**Addendum No. 1**

RE: Contract # C204204

**Wake County (P-5720)**

GRADE SEPARATION OF SR-2006 (DURANT ROAD) OVER CSX S LINE  
RAILROAD IN RALEIGH

S-27  
TOTAL SHEETS  
33

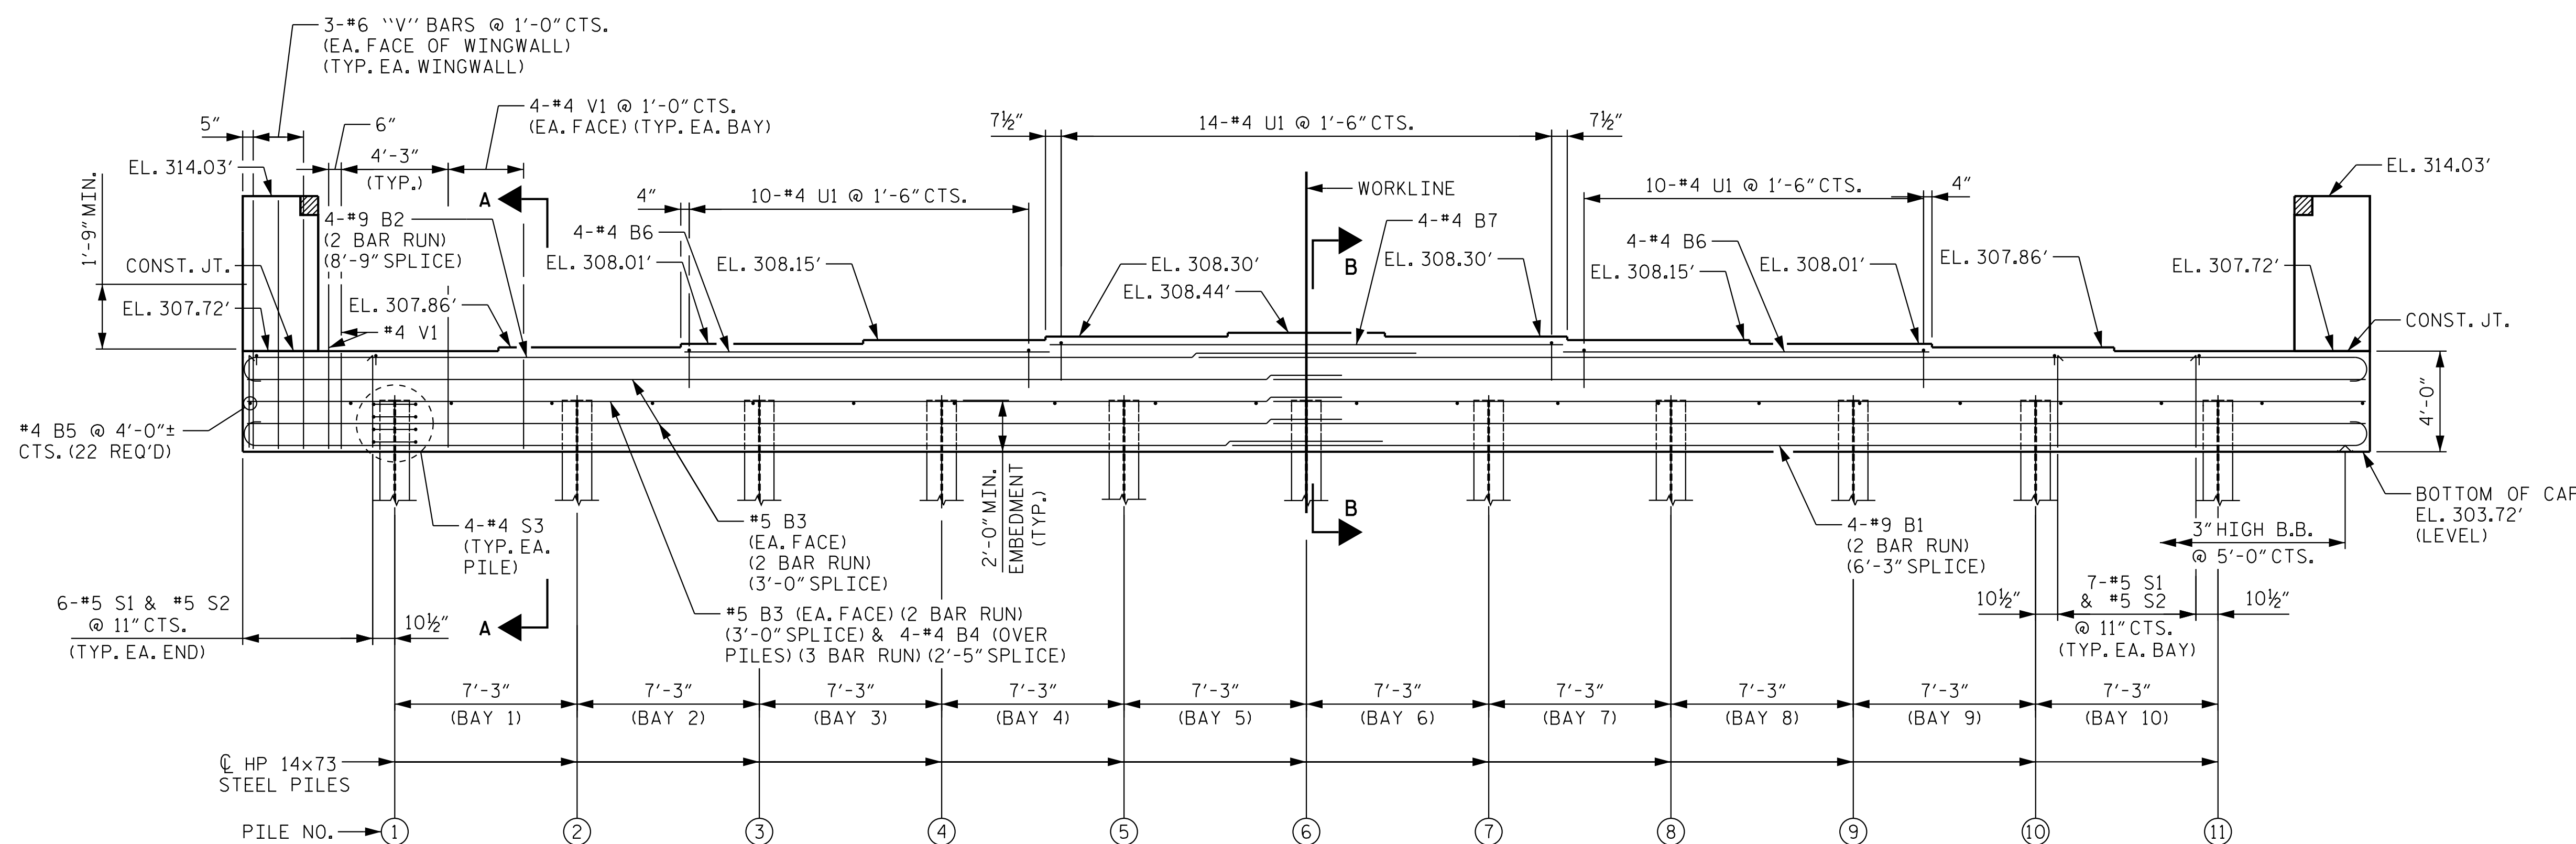
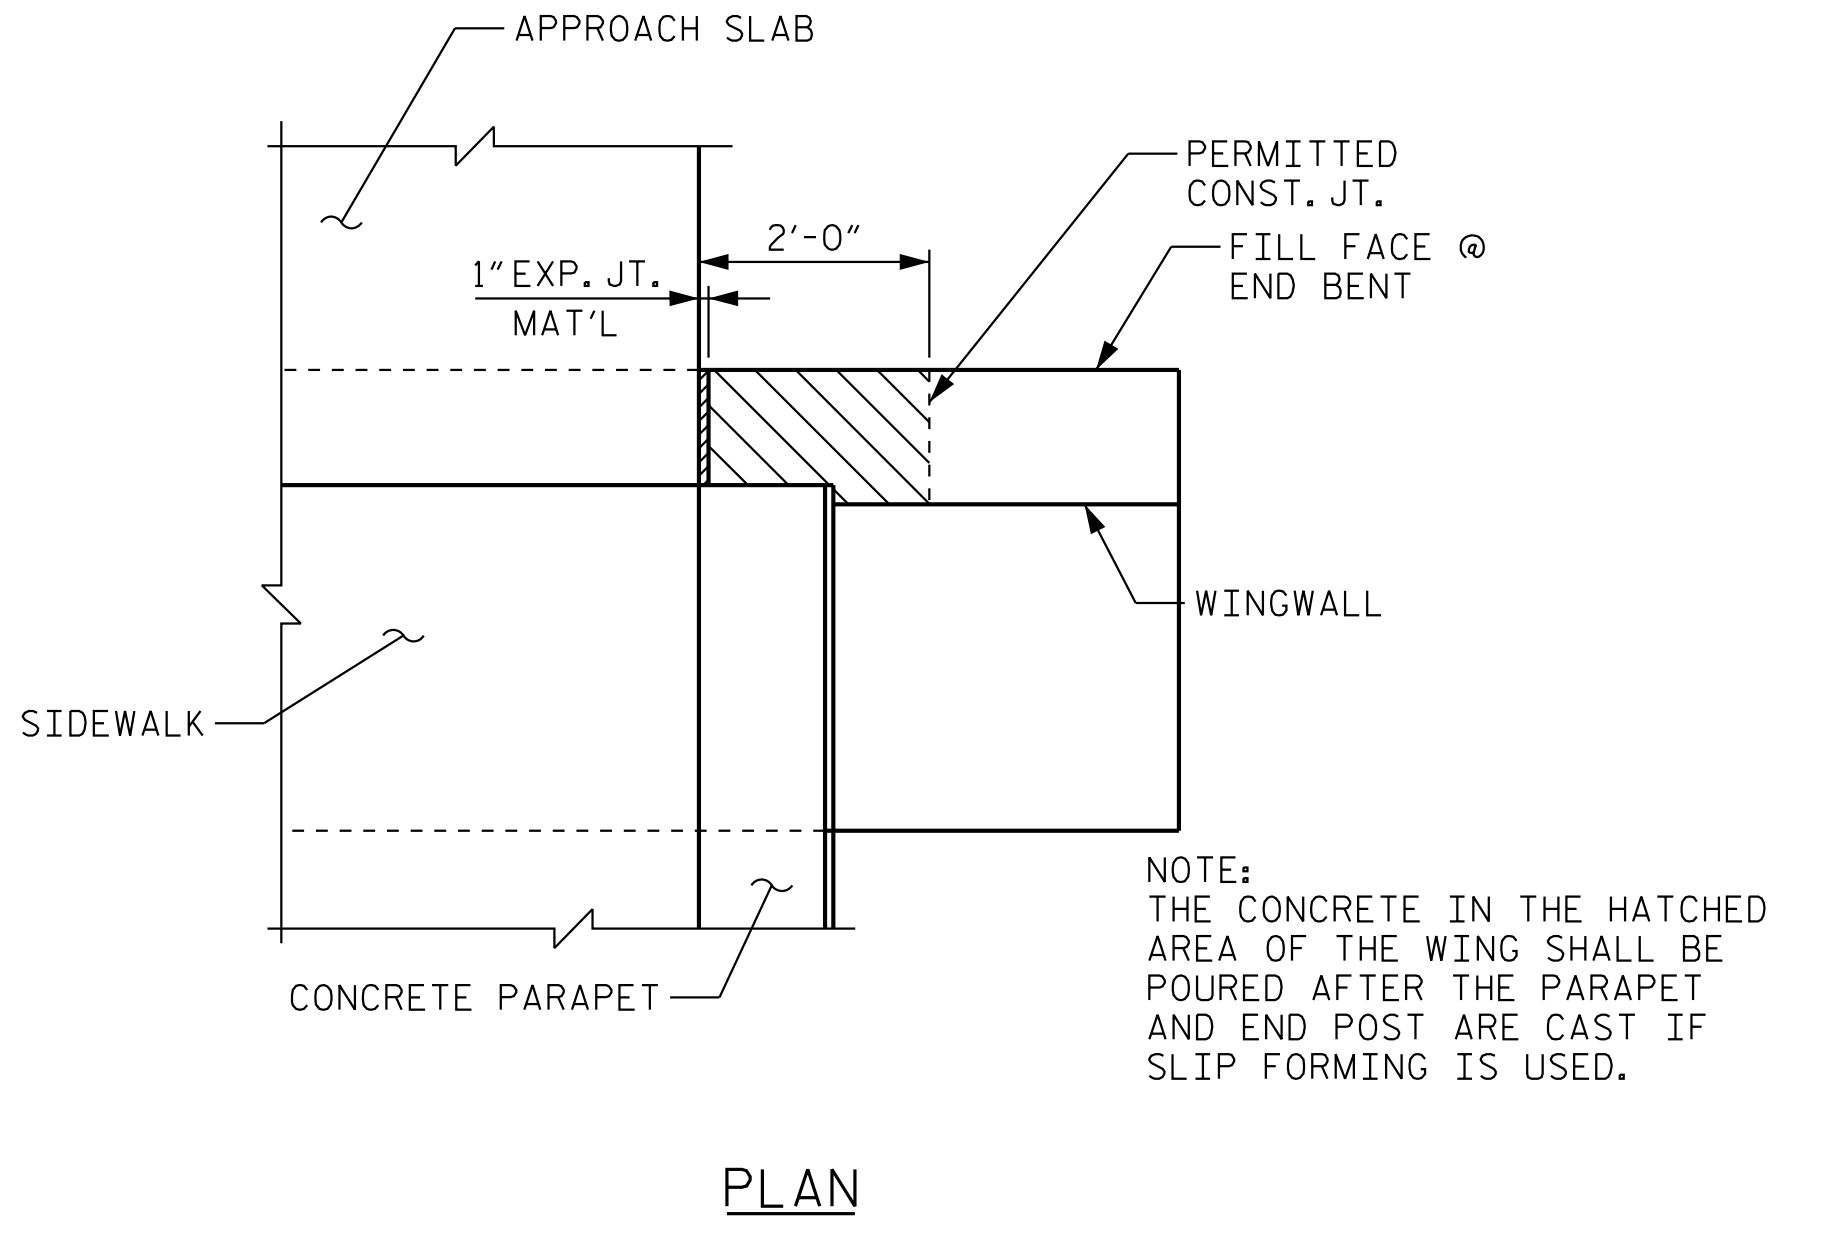
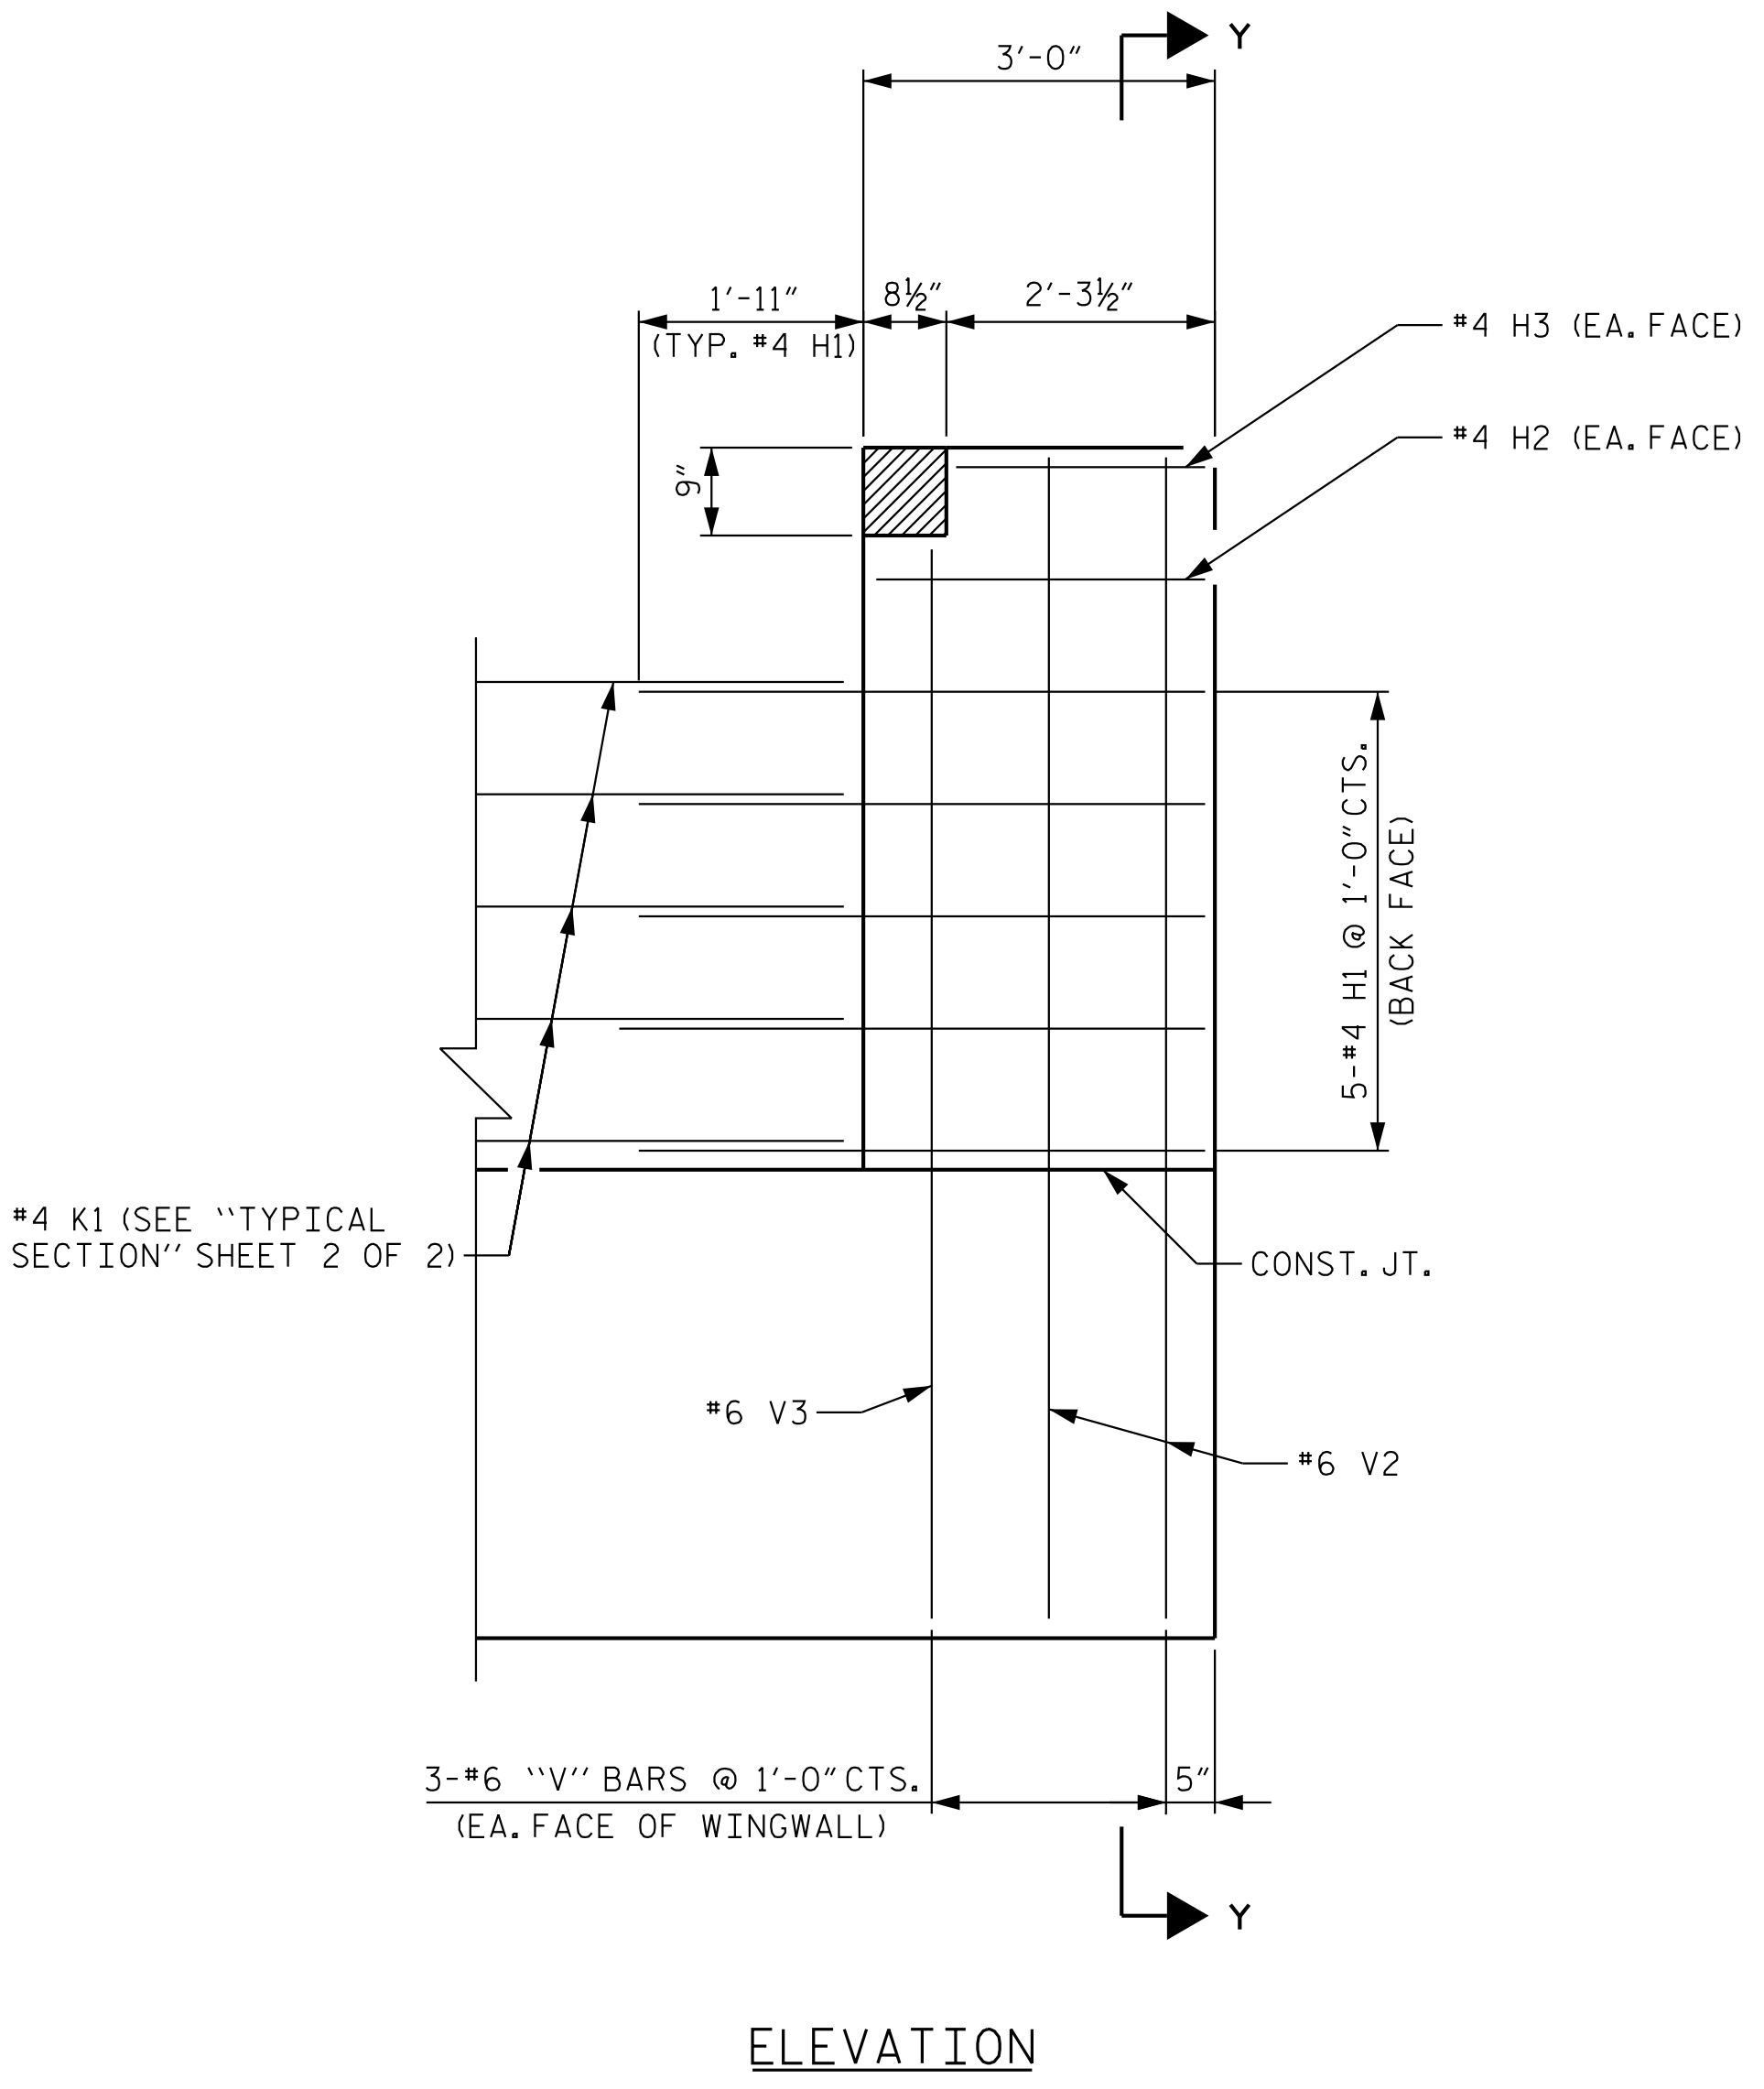
S-27	Updated V1 bar configuration for 54" FIB and beam seat elevations.
S-28	Wing steel corrected.
S-29	Updated quantity of V1 for 54" FIBs.
S-30	Updated berm elevations.
S-31	Approach Fill type revised.
S-32	Overhang depth corrected.
